Application H12-0474-25
Location 2 SCHOOL LANE LUTTON SPALDING PE12 9HW
Proposal Increase number of children from 16 to 21 in connection with current child minding business (Modification of Condition 3 of H12-0598-22) and siting of log cabin in association with business

Name Diane Gordon
Address SHDC Environmental Protection

2 School Lane
BLOCK PLAN

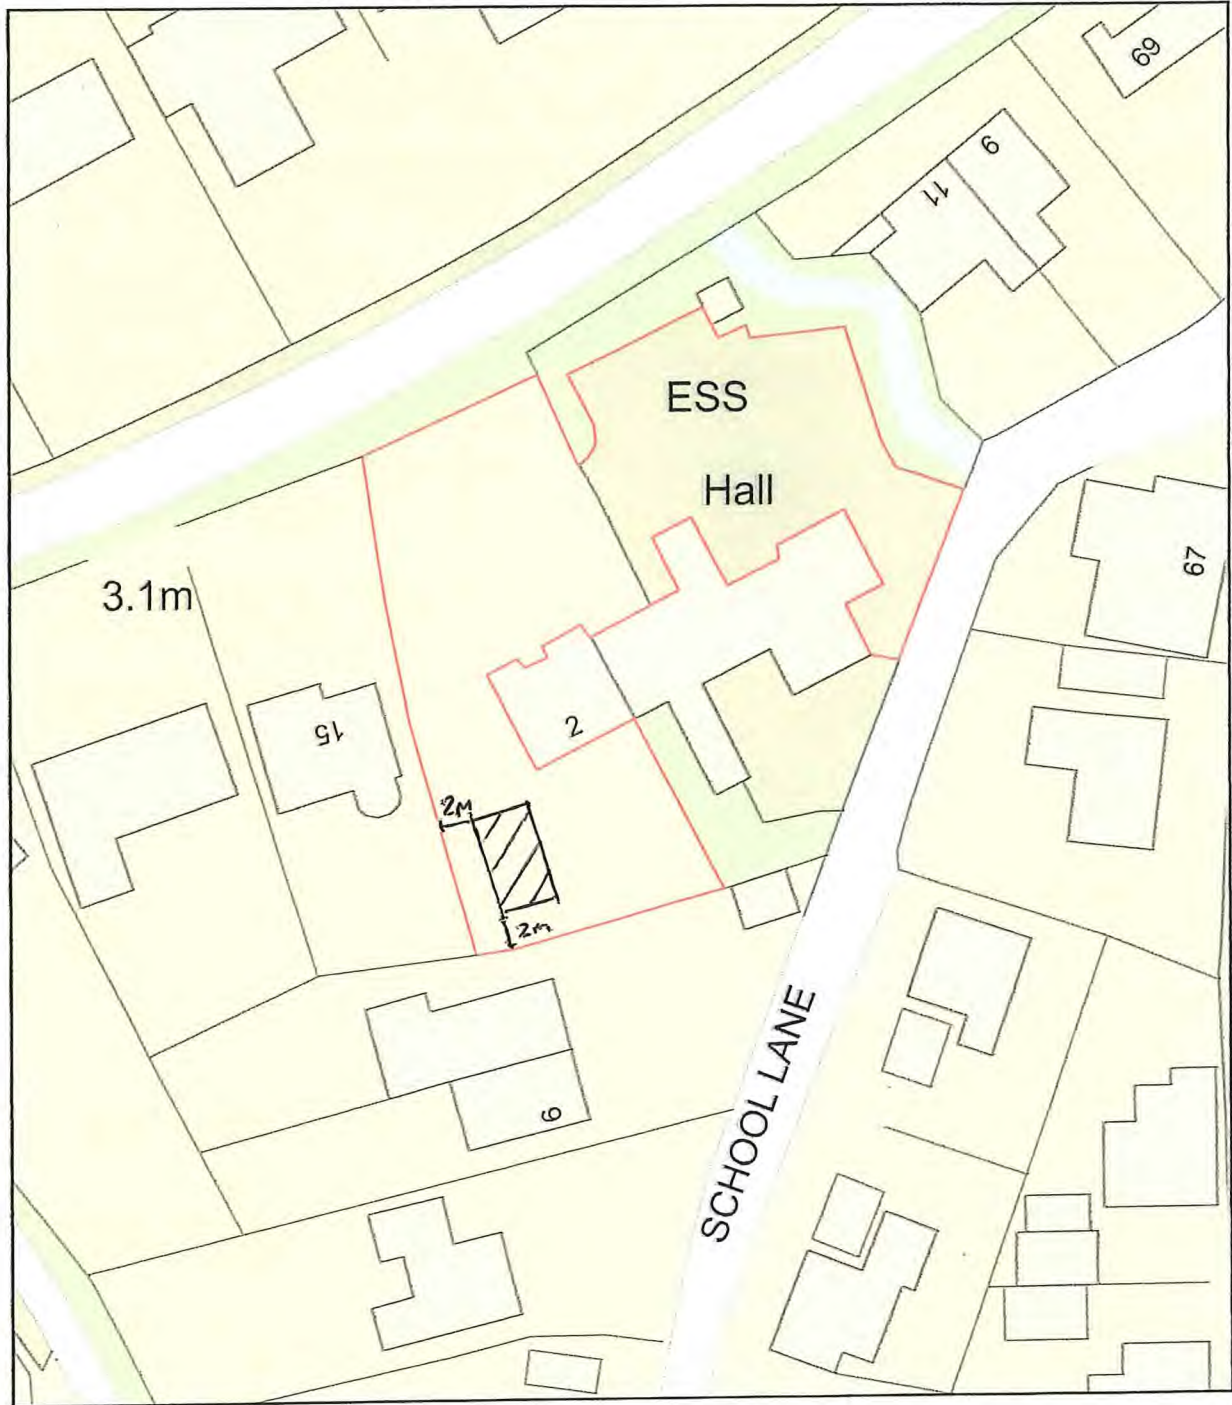
we note that the proposed increase in numbers has now been reduced.
the proposed cabin is likely to have a shielding effect and reduce noise to neighbouring properties. in addition we would advise that access to the boundary with the nearest property on Ropers gate is restricted for children to reduce any potential impact and disturbance
